Development Review Checklist

IS-FBC

Level I / Level II / Level III / Master Plan
 Project Name: Home 2 Hotel
 Address: 203 Fore Street
 Description: Alteration / Addition / **New Construction**
 Date Received: 03/14/18 Prelim / Final
 Planner: Caitlin Cameron

LANDSCAPE PLAN
 1/16" = 1'-0"

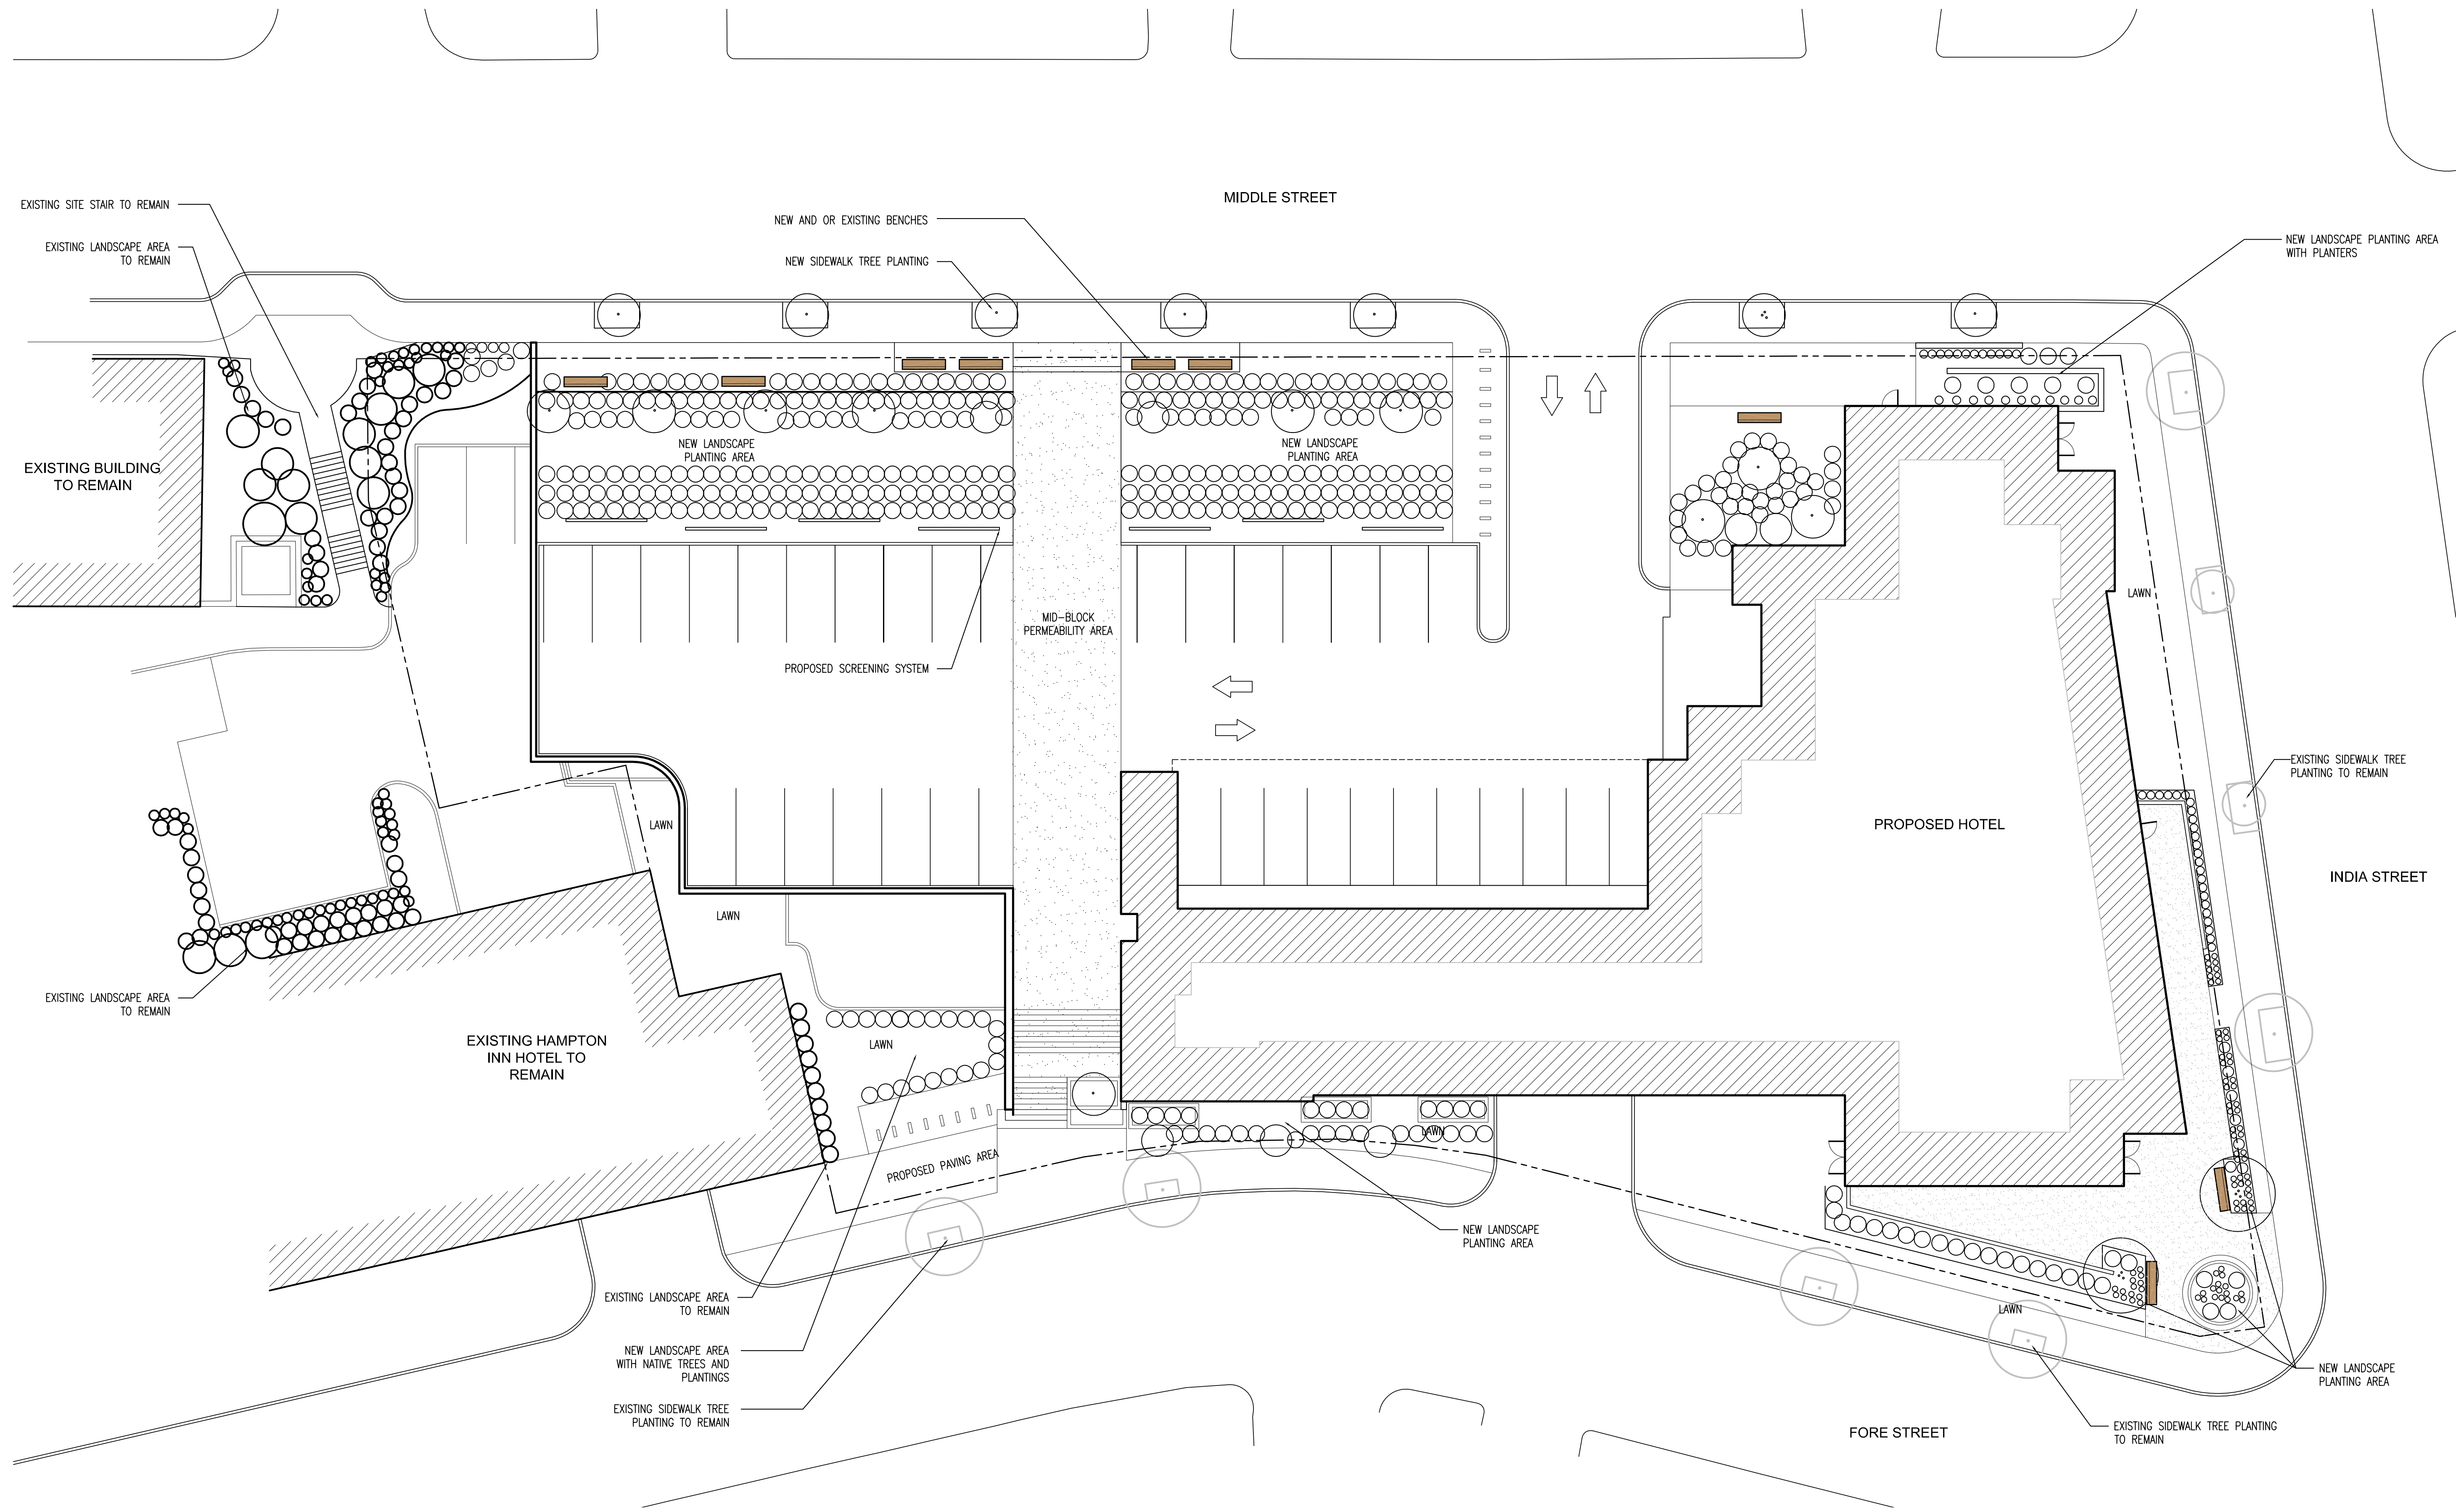
| | Complies | More Info | Does Not Comply | N/A | Comments |
|--|-------------------------------------|-------------------------------------|--------------------------|-------------------------------------|---|
| Surface Parking | <input type="checkbox"/> | <input checked="" type="checkbox"/> | <input type="checkbox"/> | <input type="checkbox"/> | Surface parking must be screened from view of Middle Street and Fore Street sidewalk |

| Standard 8.2 | <input type="checkbox"/> | <input checked="" type="checkbox"/> | <input type="checkbox"/> | <input type="checkbox"/> | Landscaping is appropriate here as screening |

FLOOR PLAN LEVEL 01 - FORE STREET
 1/16" = 1'-0"

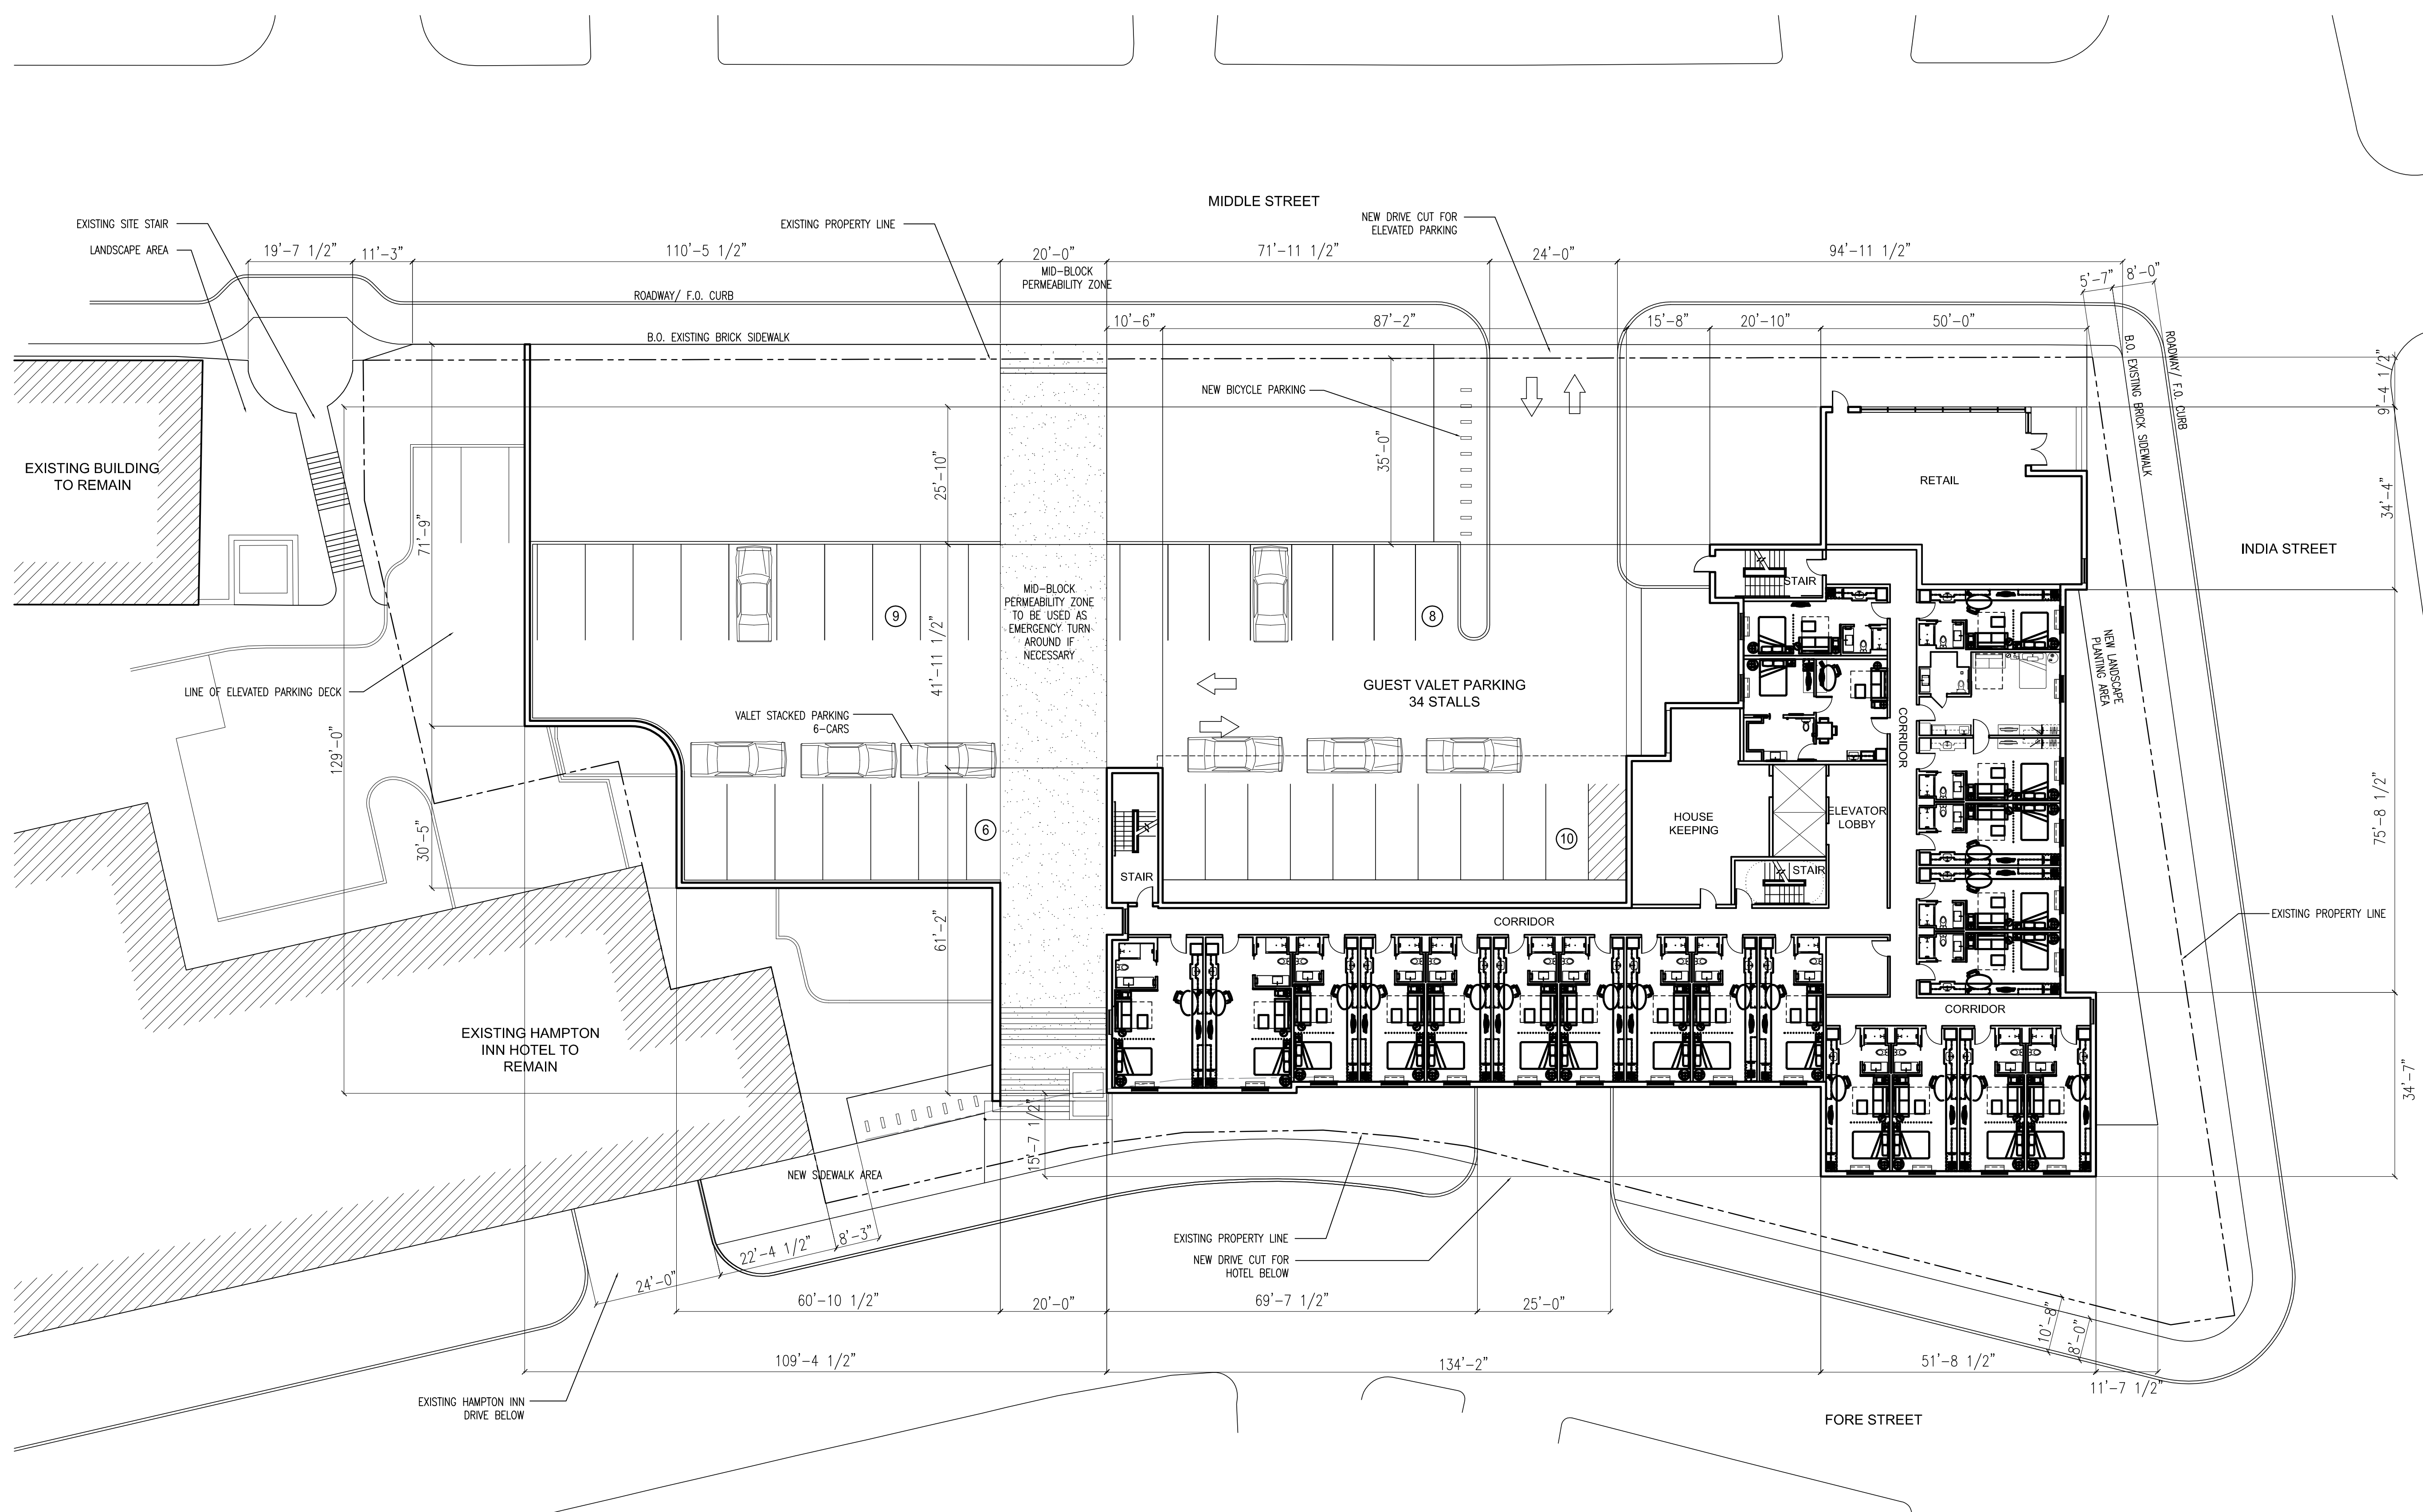
| Garage Door Setback | <input type="checkbox"/> | <input checked="" type="checkbox"/> | <input type="checkbox"/> | <input type="checkbox"/> | Garage opening is at least 10' from street – not clear if door is proposed |
| Garage Door Opening | <input type="checkbox"/> | <input checked="" type="checkbox"/> | <input type="checkbox"/> | <input type="checkbox"/> | Garage opening is 33' (20' max door width) – not clear if door is proposed |

| | Complies | More Info | Does Not Comply | N/A | Comments |
|------------------------------|-------------------------------------|-------------------------------------|--------------------------|--------------------------|---|
| Standard 6.6 | <input type="checkbox"/> | <input checked="" type="checkbox"/> | <input type="checkbox"/> | <input type="checkbox"/> | Is a garage door proposed? |
| Intent | <input type="checkbox"/> | <input checked="" type="checkbox"/> | <input type="checkbox"/> | <input type="checkbox"/> | More information needed on the articulation and detail of the garage on Fore Street. |
